TERRA RIDGE NORTH CIVIL CONSTRUCTION PLANS El Paso County, Colorado

Prepared By:
Lodestar Engineering, LLC
P.O. Box 88461
Colorado Springs, CO 80908
FEBRUARY, 2023

EL PASO COUNTY DEVELOPMENT
REPLAT TERRA RIDGE LOTS 5 & 6 W/ 11 LOTS IN
TERRA RIDGE NORTH
COVER SHEET

MAINTENANCE & ACCESS ROAD
ABOVE EURV TYPICAL SECTION

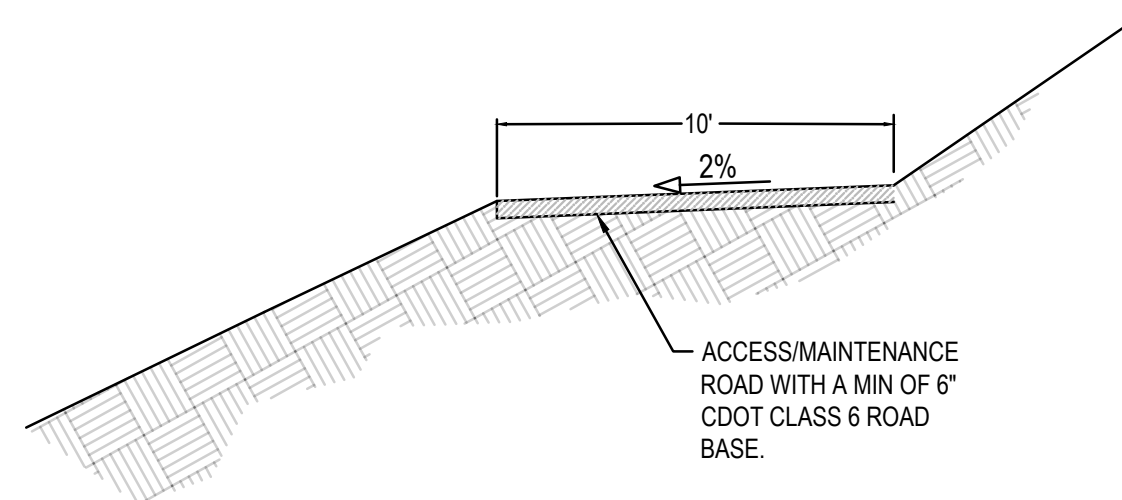
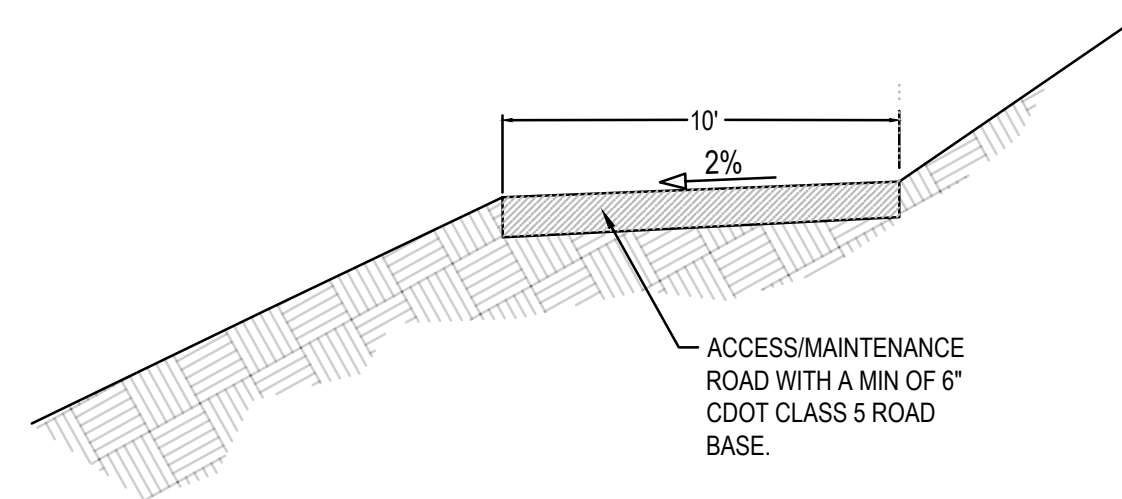
Unresolved comment from Review 1: Provide access road detail/cross section, including stone sizing and gradation. Show cross slope at 2%.

Review 2 clarification: I see that you have added 2% slope callouts. But I'm still not seeing a detail. See example detail provided above.

Unresolved comment from Review 1: -Stabilized access ramp shall be a minimum of 15ft wide and no greater than 12% slope, in accordance with DCMv1, Chap 11.2.2.

Review 2 clarification: per email discussion with Shay about this on 2/3/22, I had stated that a 10ft wide road is acceptable as long as it is documented in the O&M manual (non-provided with Review 2) that the anticipated equipment can access with a 10ft width. But the 12% slope criteria still needs to be adhered to. So show that on these plans.

EL PASO COUNTY DEVELOPMENT
REPLAT TERRA RIDGE LOTS 5 & 6 W/ 11 LOTS IN
TERRA RIDGE NORTH
POND A OUTLET STRUCTURE DETAILS

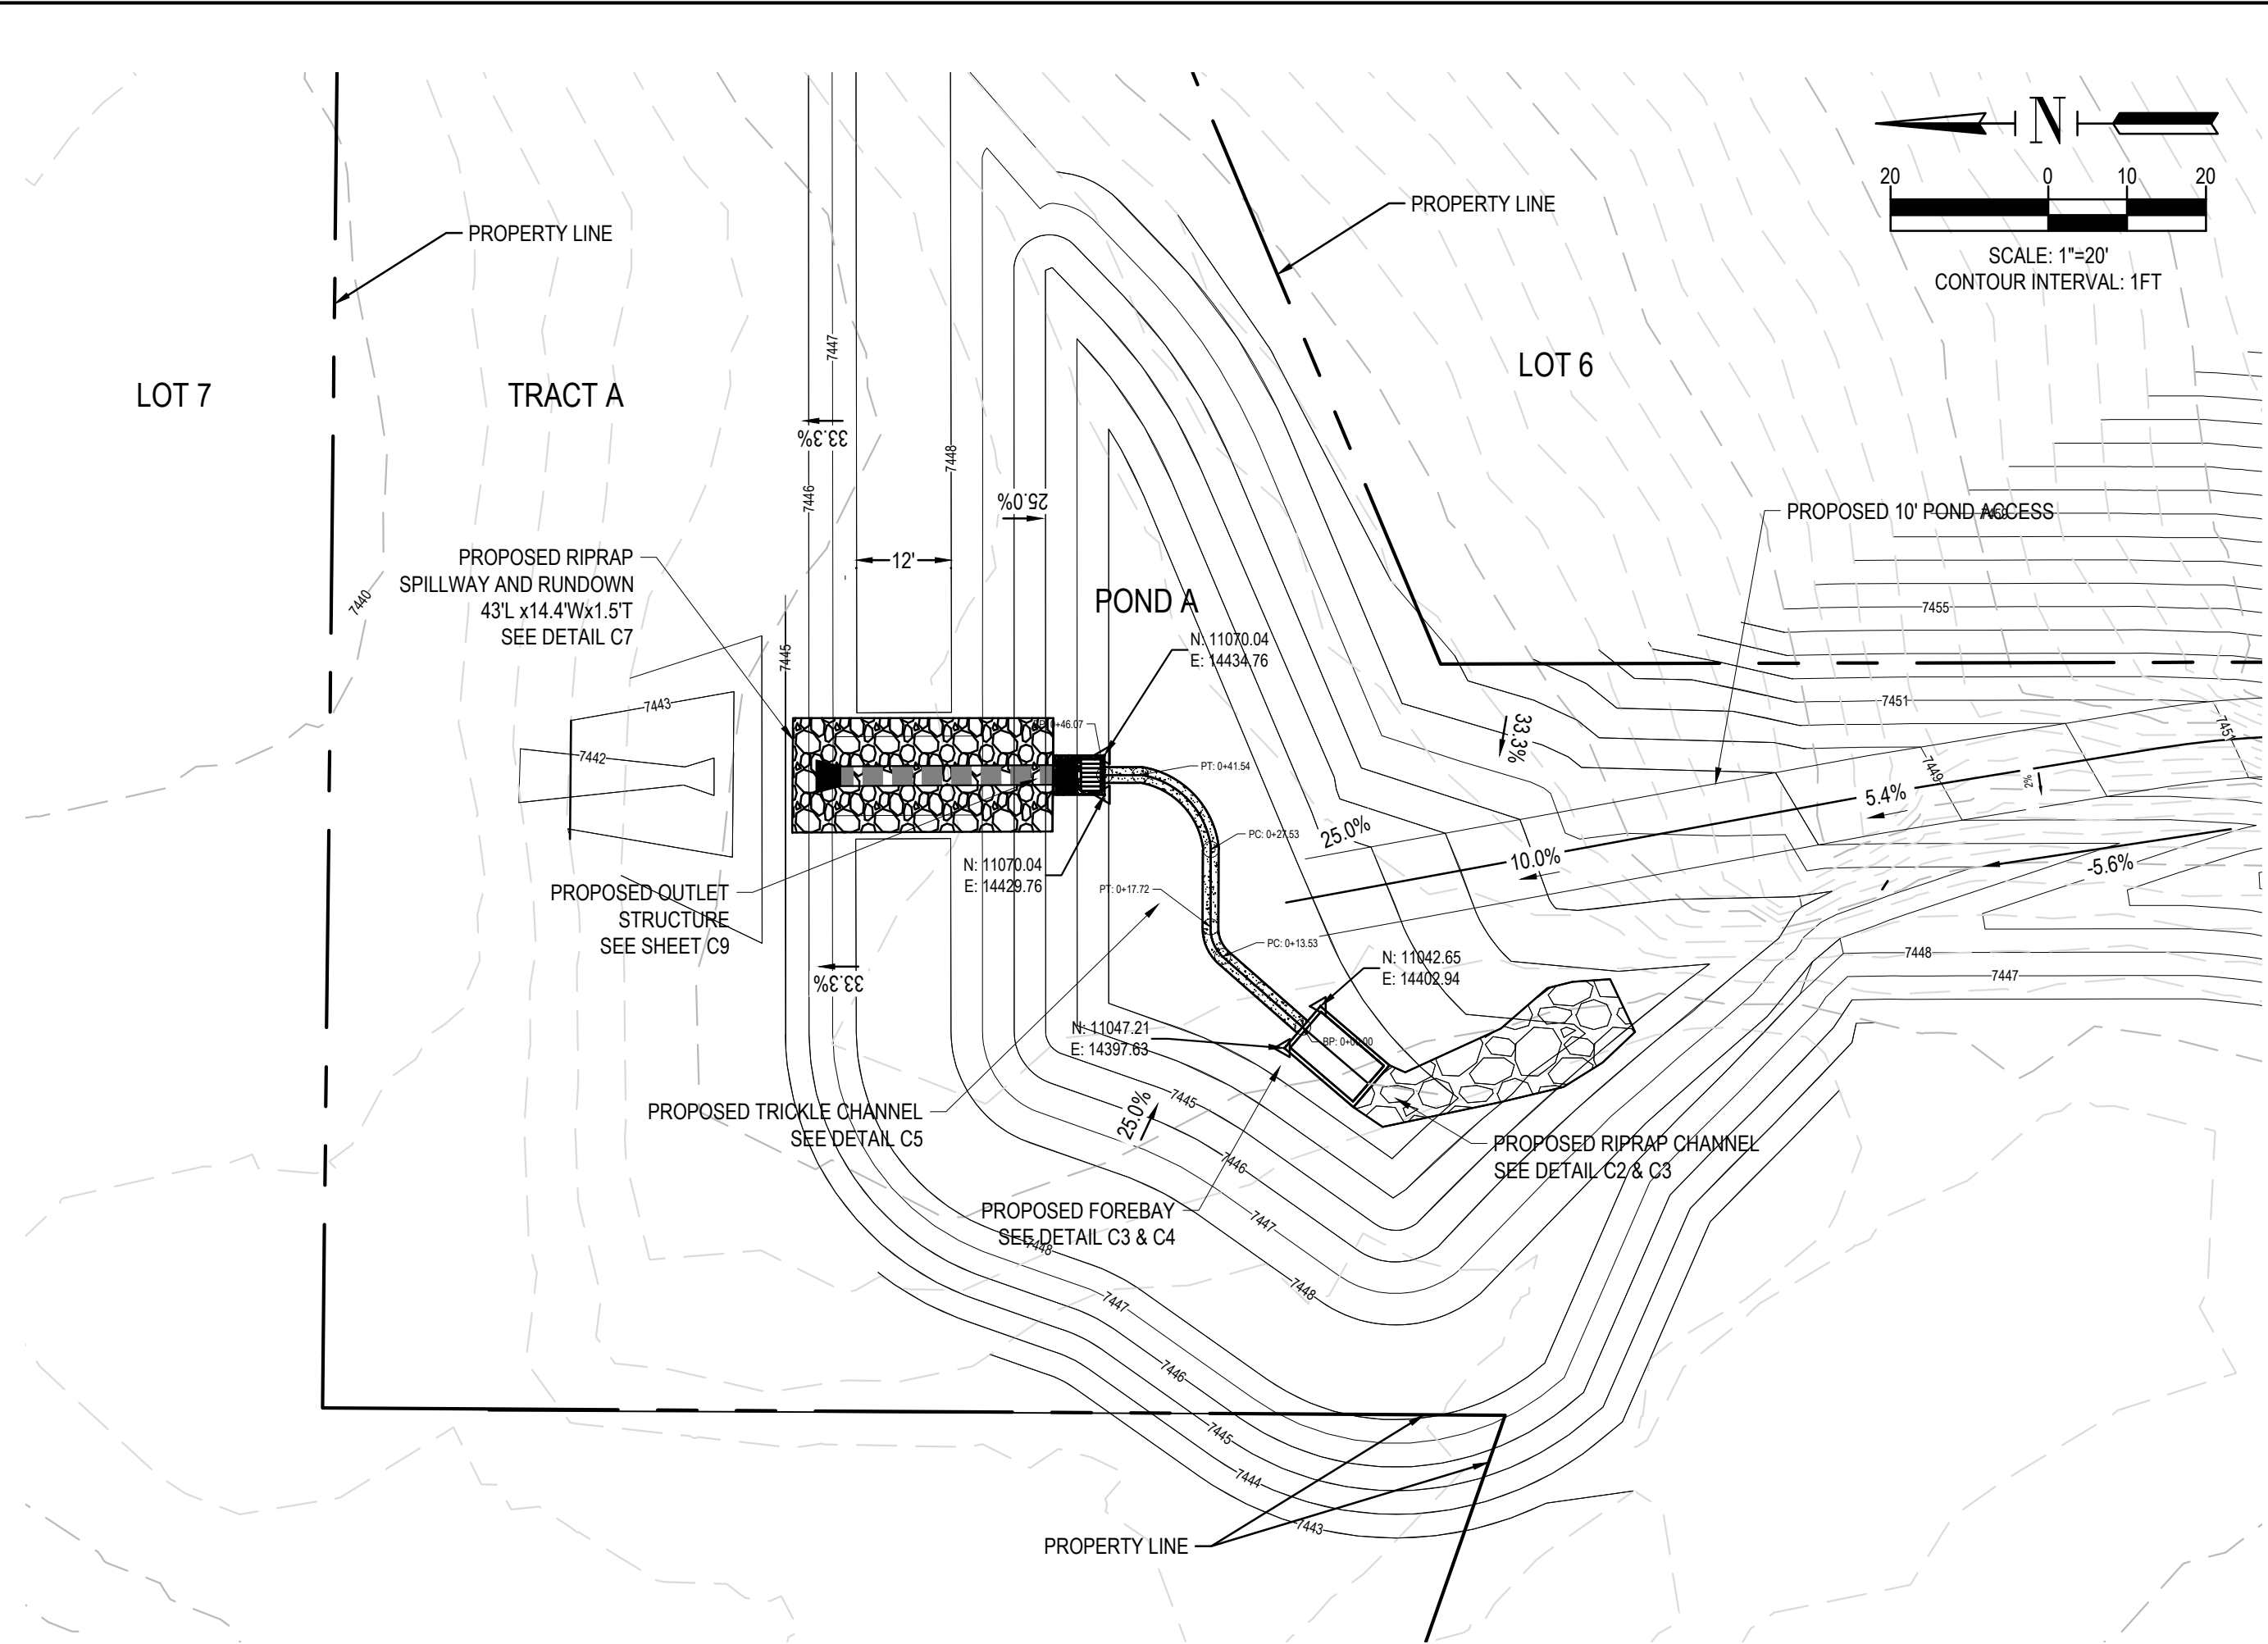
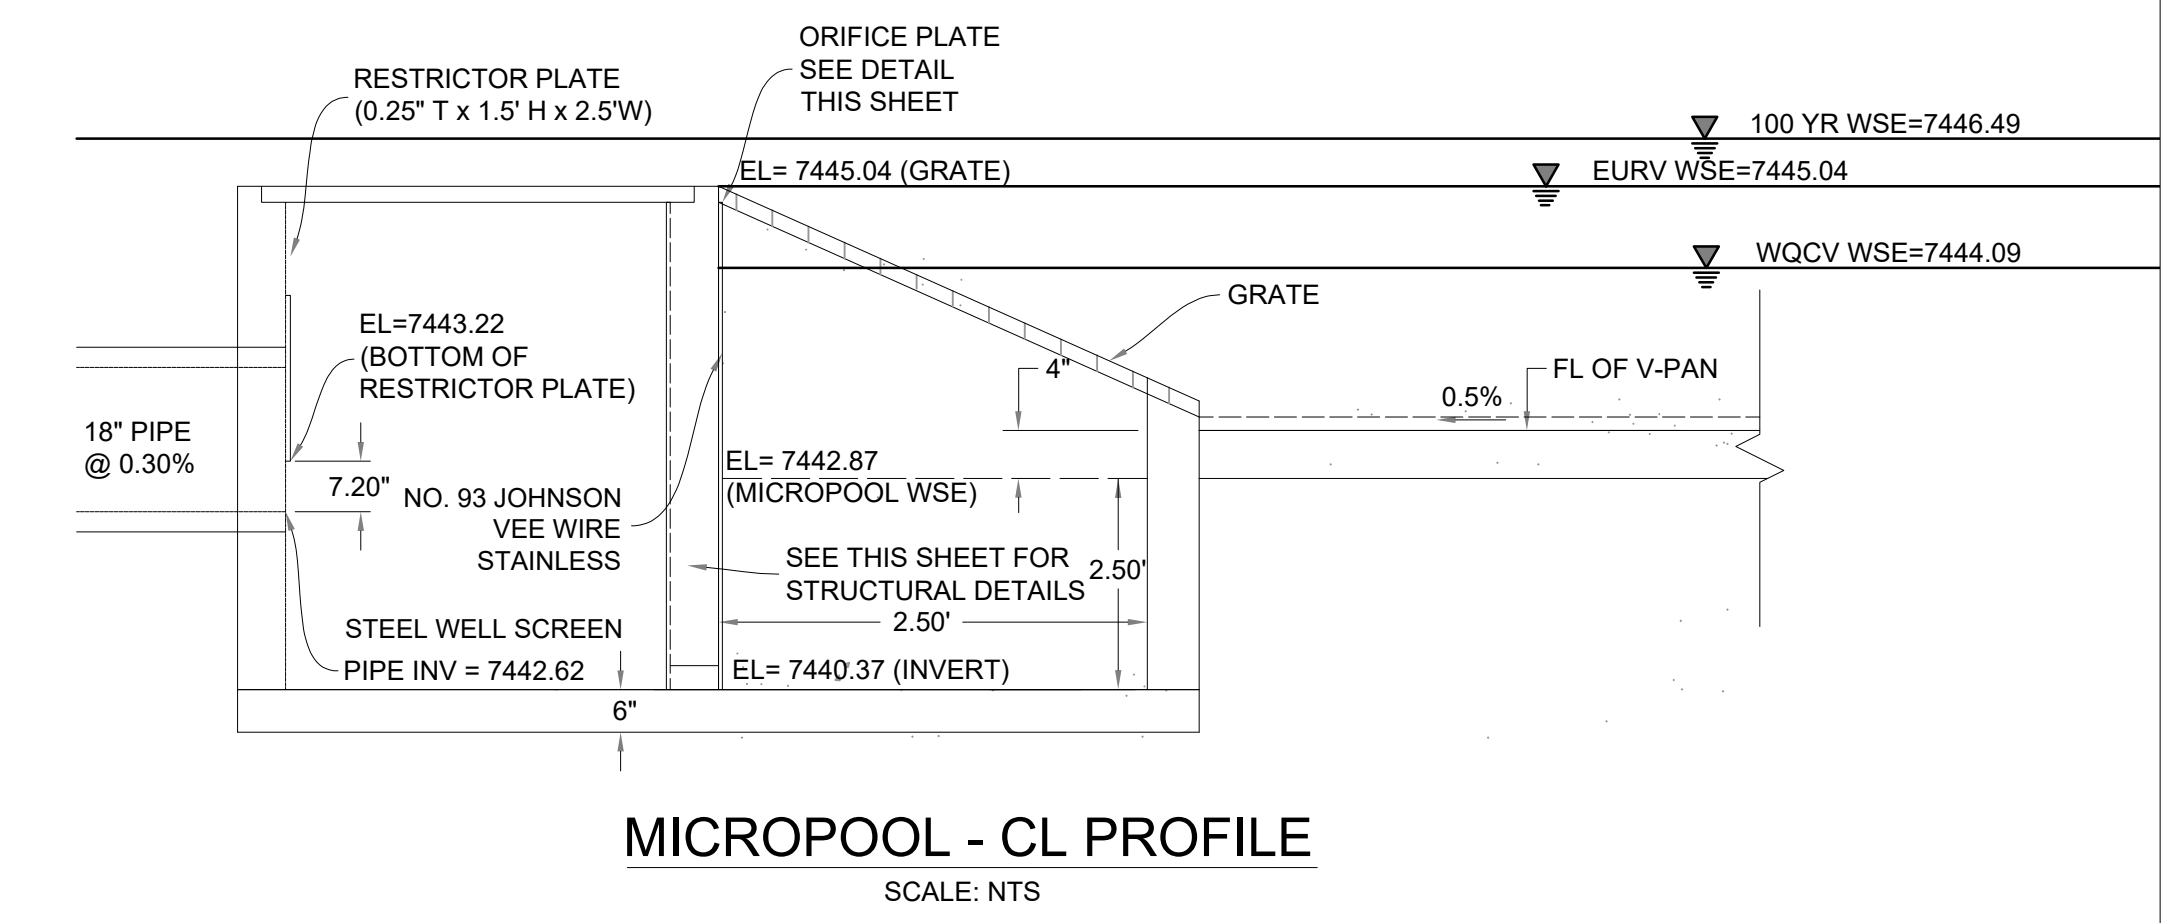
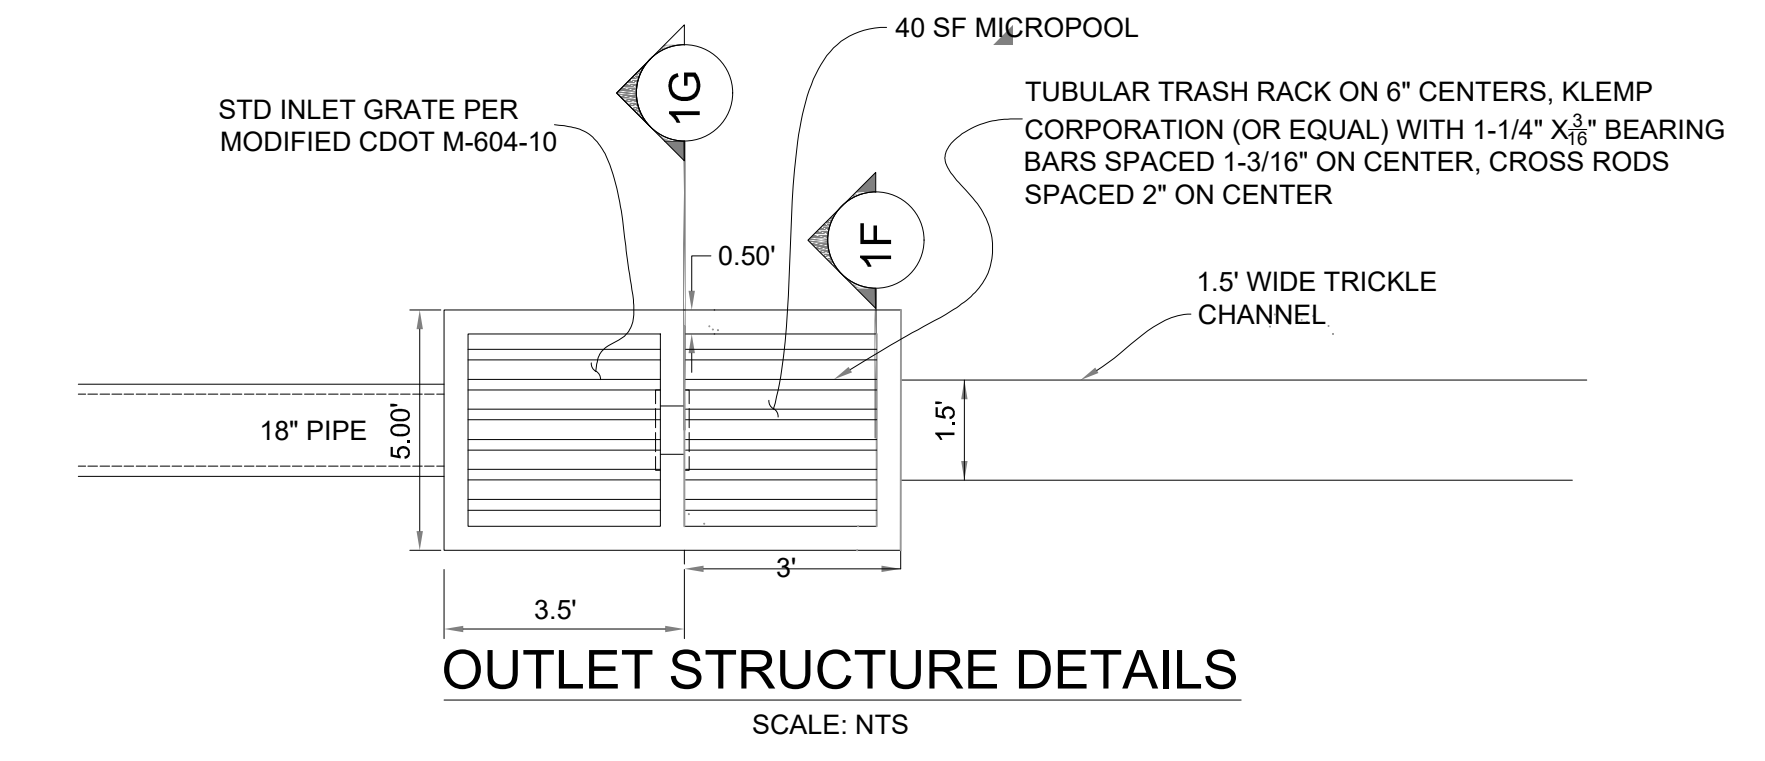
Unresolved. provide information for the grate to be installed on the second chamber
